**City of Albuquerque Stormwater Construction Site Inspection Report**

ESC File No.	K09E002	Project Name:	9101 Central Ave NW		
NPDES Id. No.	NMIR1006B5	Location:	9101 Central Ave NW		
5/5/2025	Owner		Contractor		
Operator	Cosme Jaquez		Cosme Jaquez		
Contact name & title	Cosme Jaquez		Cosme Jaquez		
e-mail	jaquez.aylin14@gmail.com		jaquez.aylin14@gmail.com		
Contact Phone #	505-250-7216		505-250-7216		
<b>COA Inspector</b>	<b>James Hughes</b>		start	11:30am	
Construction Phase:	earthwork				
Type of Inspection:	Regular	Storm Event	Post Storm Event >0.25"	311/Complaint	Follow Up
Weather at time of inspection?	Temperature: ~			50	
Estimated date of last storm 0.25" or greater	5/4/2025

EROSION AND SEDIMENT CONTROL PLAN PHASE II FINAL

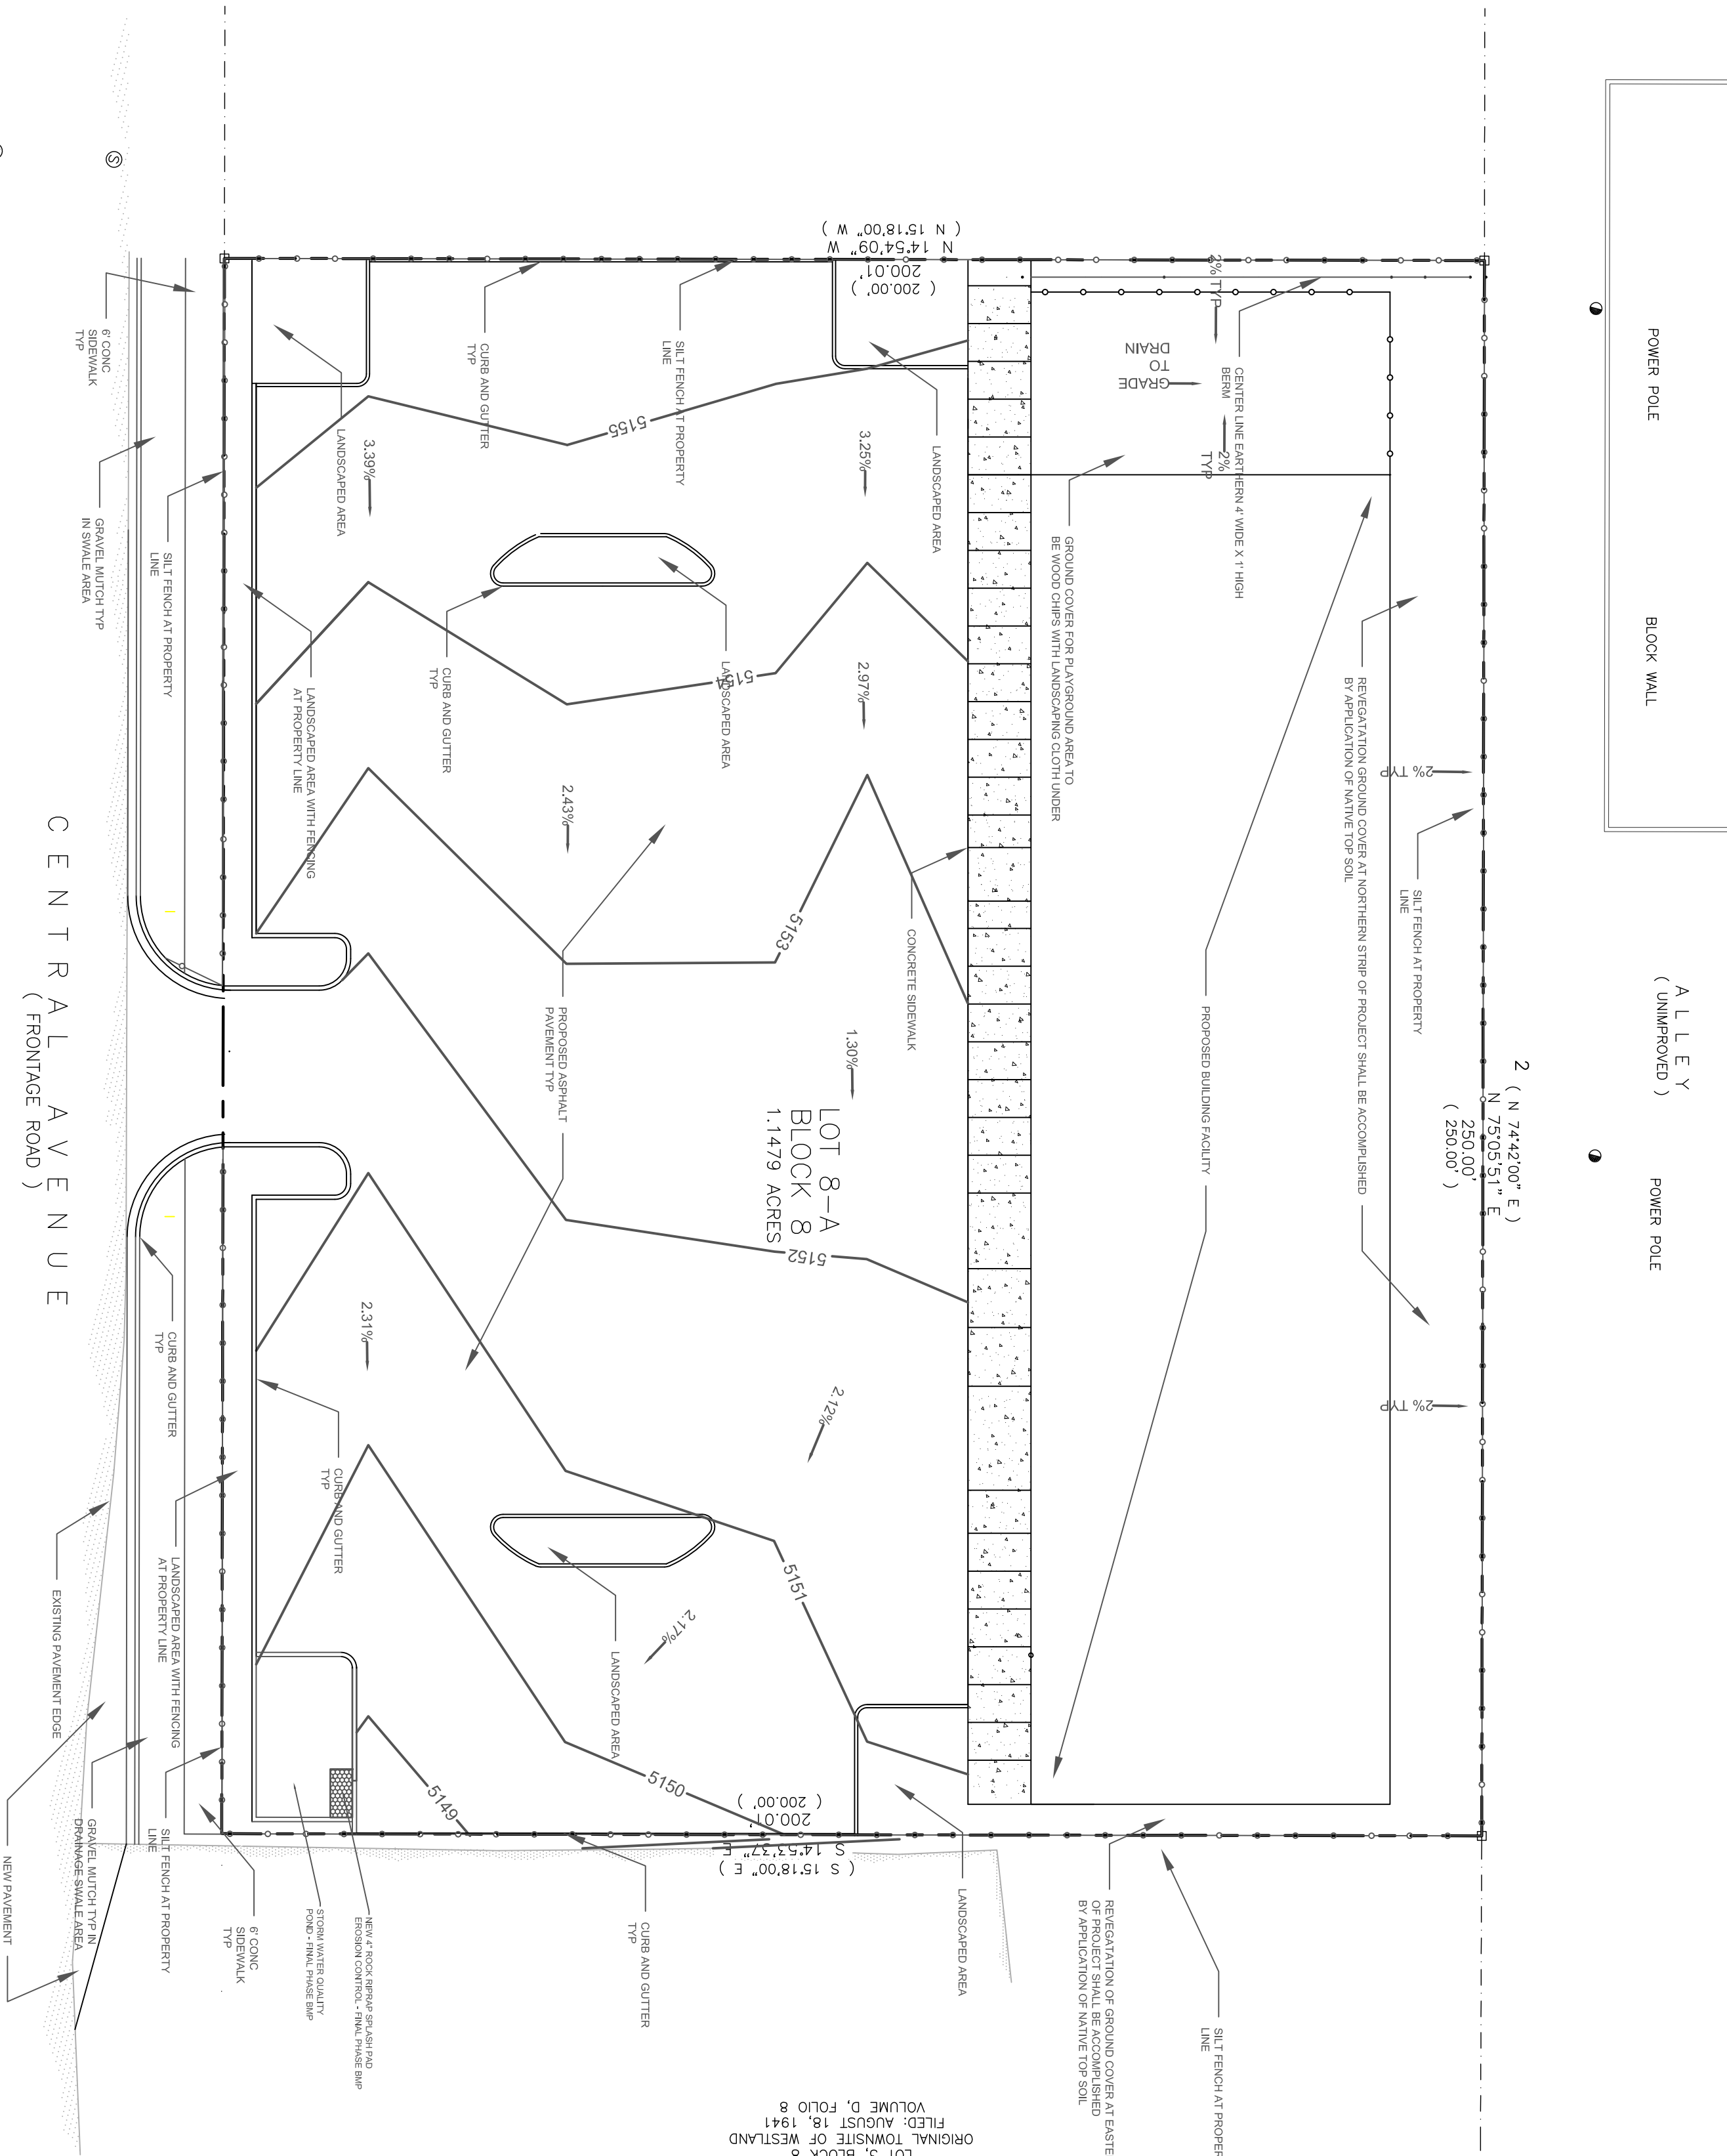
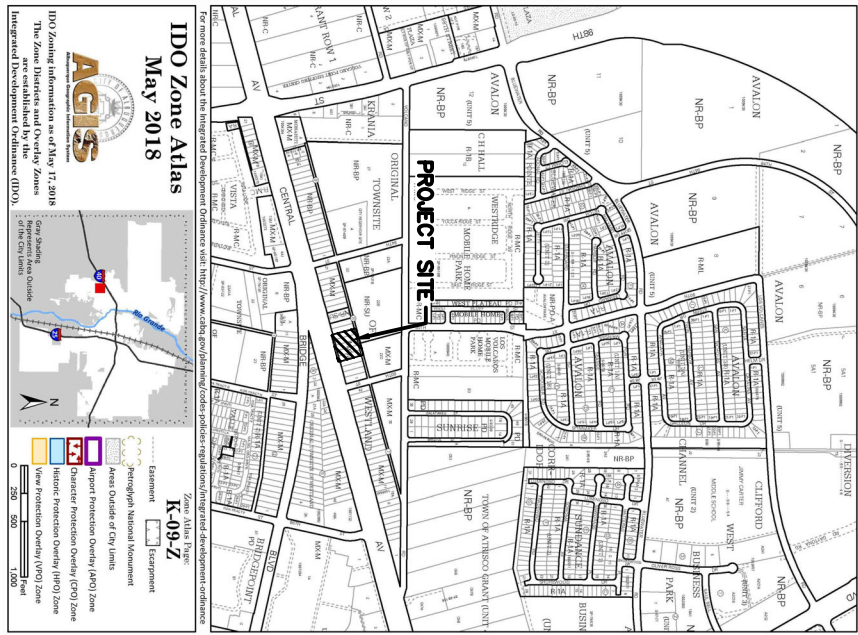
3	<p><b>BMPs</b> - The Silt Fence was attached to a mobile chain-link fence, so it wasn't properly installed, in violation of CGP 2.1 and CGP 2.2.3. <b>Required mitigation:</b> The silt fence must be reset, attached to stationary stakes with the fabric embedded 12" into the ground, in accordance with the Corrective Action requirements of CGP 5.2.1, no later than seven (7) calendar days from the time of discovery. If at any time you find that a stormwater control needs routine Maintenance, you must immediately initiate the necessary maintenance work and complete it by the close of the next business day.</p>
